ISH4_23 March PT3

And then we'll carry on with agenda item seven, which is landscape. Moving directly on to the first question, under that agenda item, the applicant in its responses to the Examining Authority's written questions notes that its landscape and visual impact assessment is not sensitive to any particular layout which might be possible within the design scenarios proposed. The applicant's reasoning for this, as that is that it is the height and scale of equipment, which are the main criteria that determine effects.

Photomontage Year 15

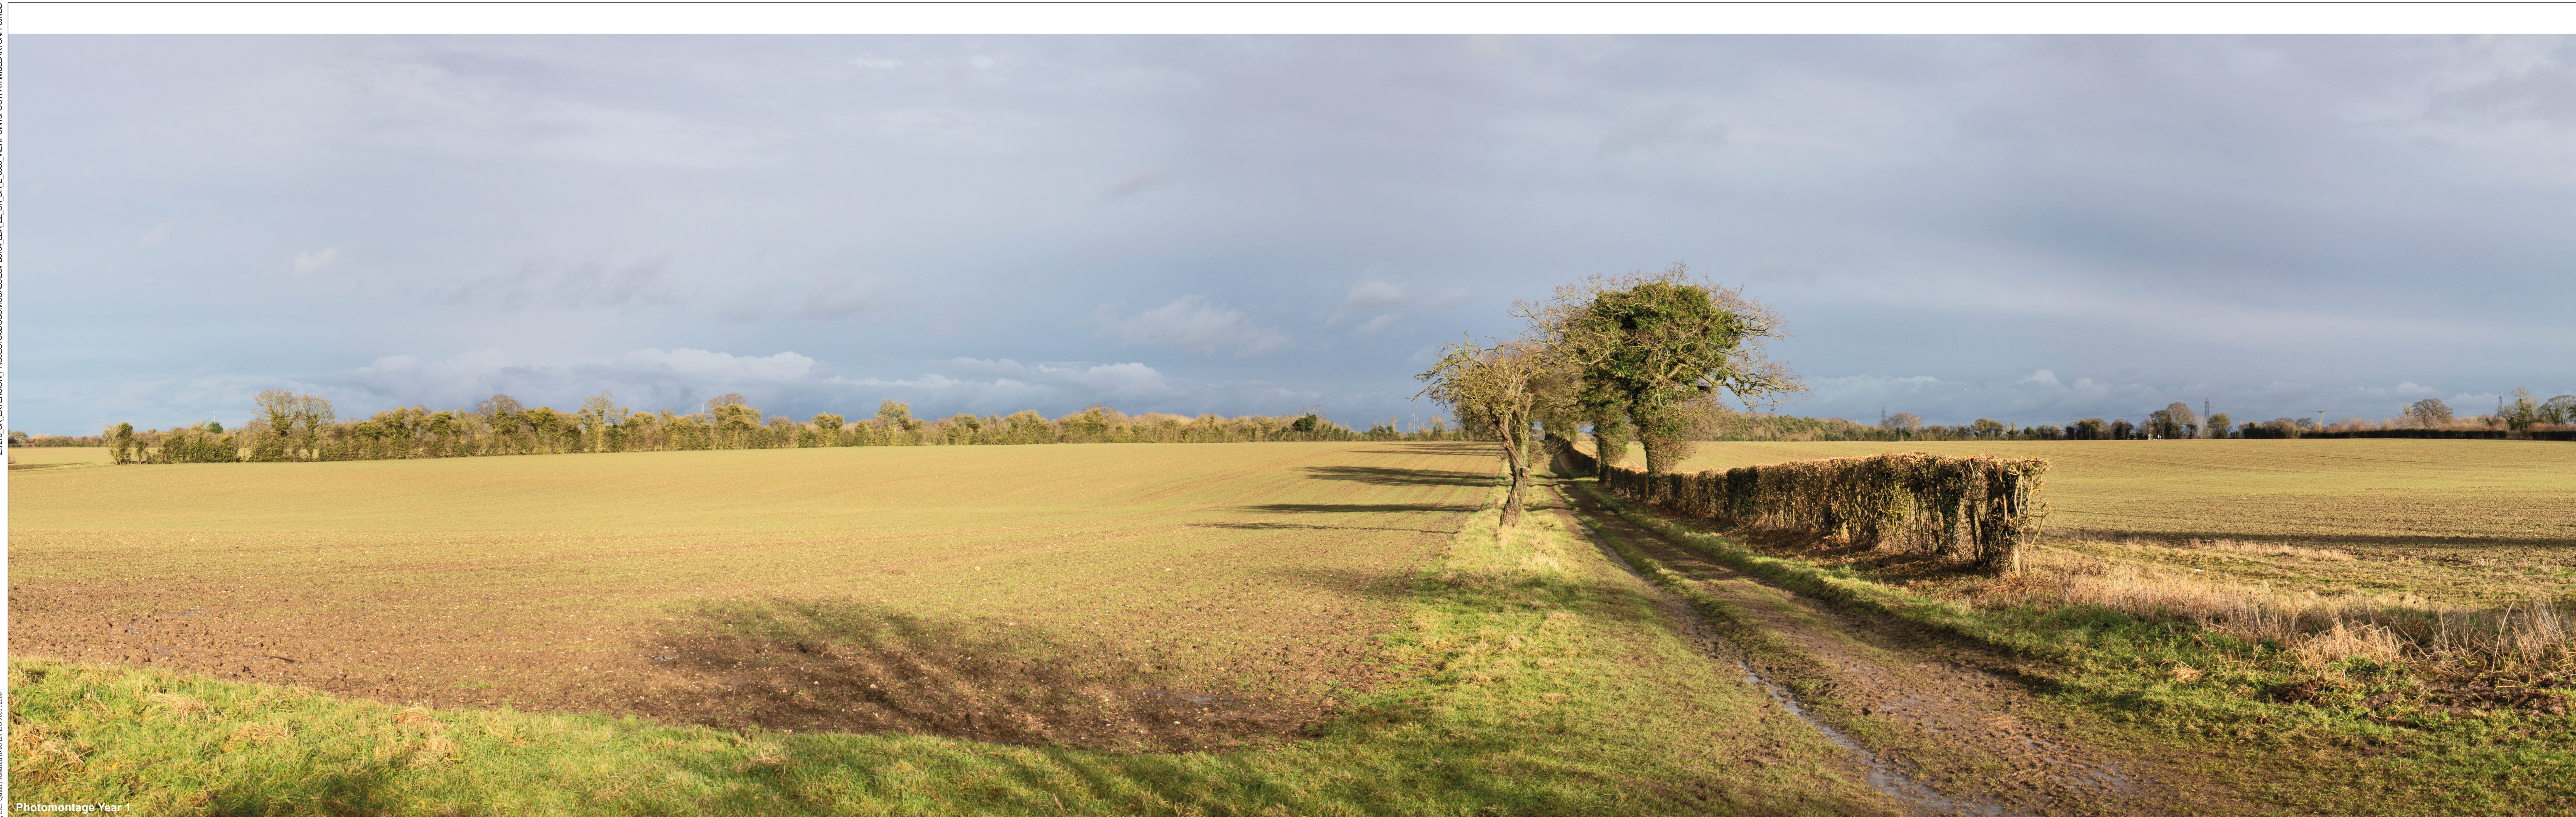
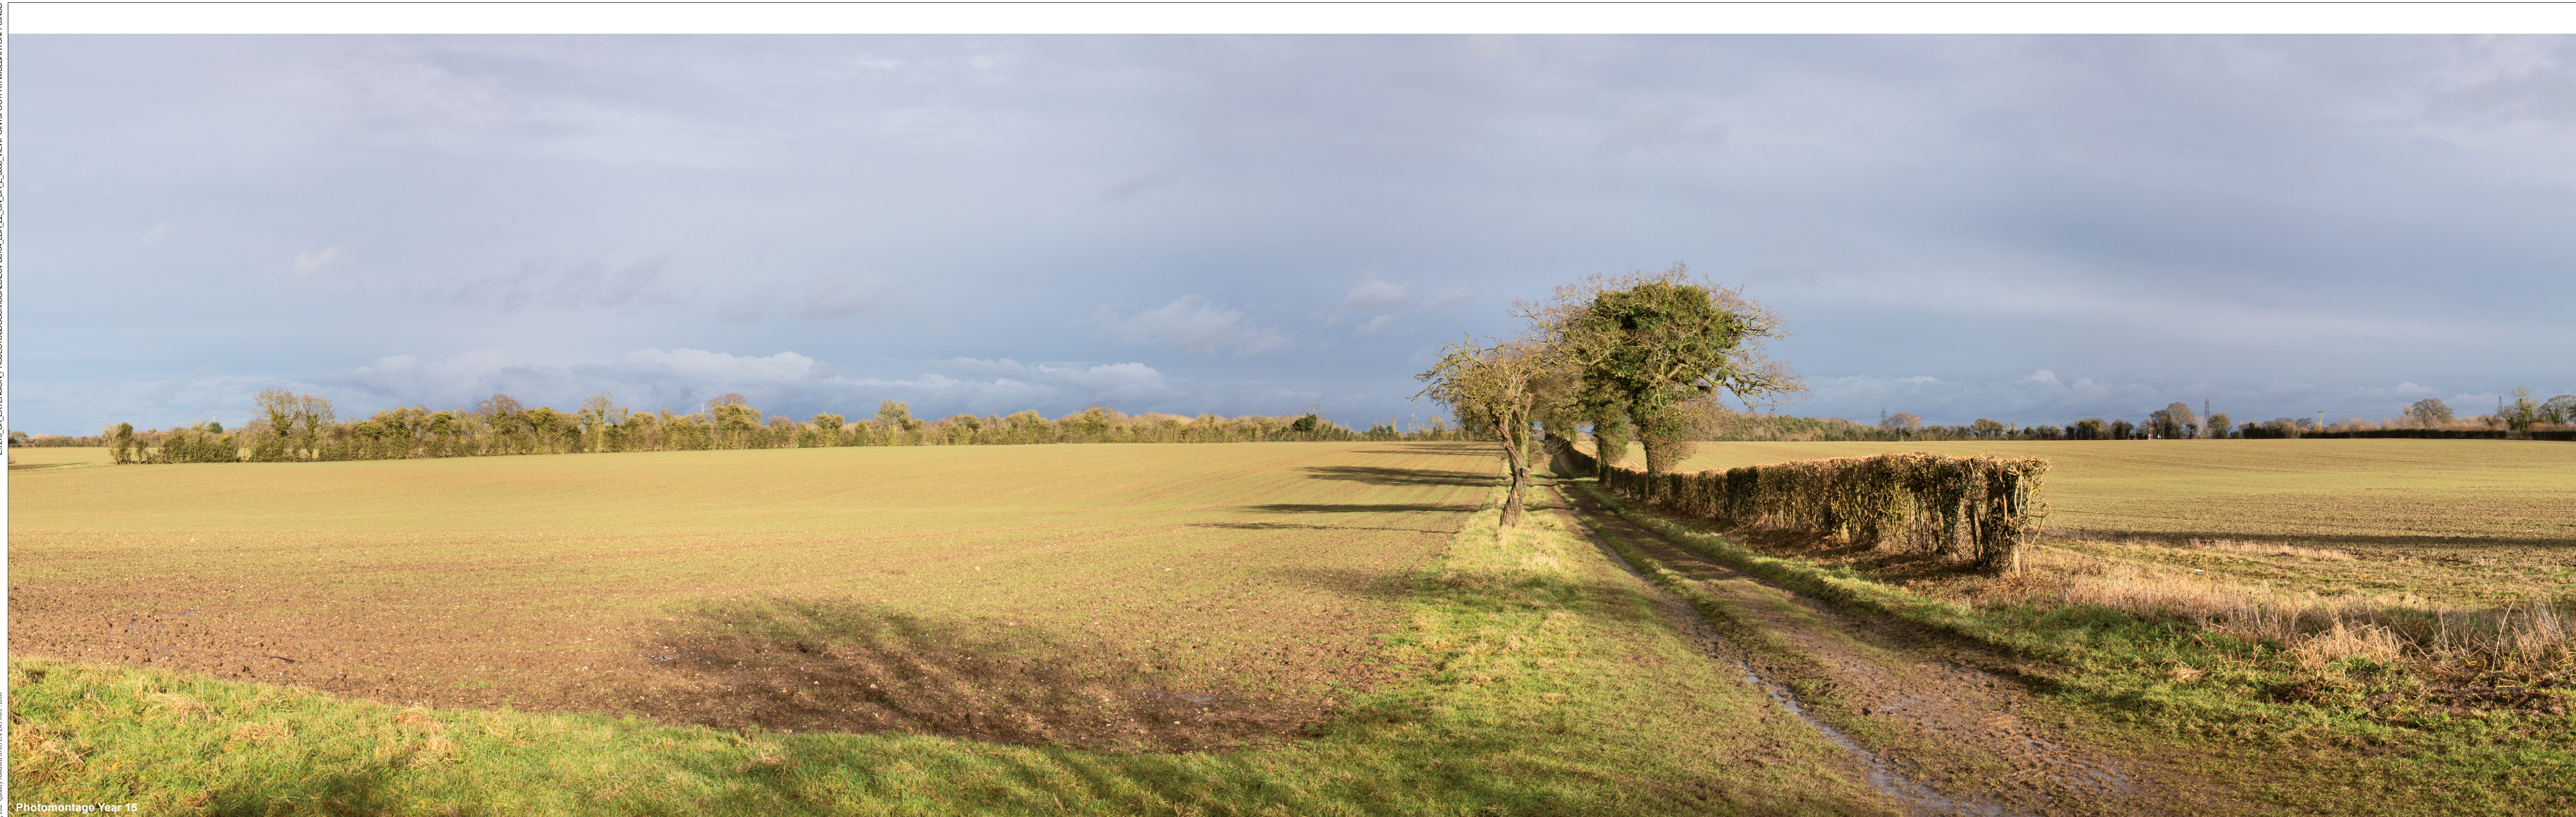
are not fixed by the very nature of them being indicative at this stage. And that is understood. The question, however, is particularly with regard to viewpoint two, is there no possibility that buildings and equipment locations could be swapped from that shown in the photo montage views?

I'm searching for the correct terminology for it. But if the the electrical infrastructure versus the I'm going to call them sheds from now on. But if the enclosed buildings versus the enclosed infrastructure were swapped handed, if in effect from the viewpoint has shown the the visual effect would be significantly worse than shown, would it not?

Um, okay. Let me go a little bit further into that. So if, if it were the case that the, the, the building, the shed which, which has a building envelope were, were effectively in the centre of the image versus off to the left hand side, it's your view that that would not be a worse visual impact than your presenting in this viewpoint.

So thank you. You may feel that you've answered this already, but if the layout layout can't be secured within within the DCO, how how can the examining authority be certain that the level of effects shown wouldn't be worse than shown currently?

I would disagree with that, but I think we need to consider that viewpoints one, two and three are east, north and west of the location. So if one is on that bridleway network, um, clearly you would see a different aspect depending on which view you are. Um, viewing it from the visual impact assessment and indeed the landscape of visual assessment obviously is a is a holistic assessment.

are quite evident. Plus you can see all the lattice work of all the electrical equipment, the bus bars and all the rest. That makes up a, um, a substation together. To my mind, that that presents itself as a substation. If different components were in slightly different positions in terms of the overall visual effect, it wouldn't change the scale of the fact, in my view, to the extent you come to a different judgement.

We've carried out an assessment.

Network of footpaths, the immediate locality, major adverse result, major adverse visual effects will occur. Um.

And that is a consequence of developing a substation in this location at a platform height as determined within that landscape setting with no none of the electrical kit greater than 15m and
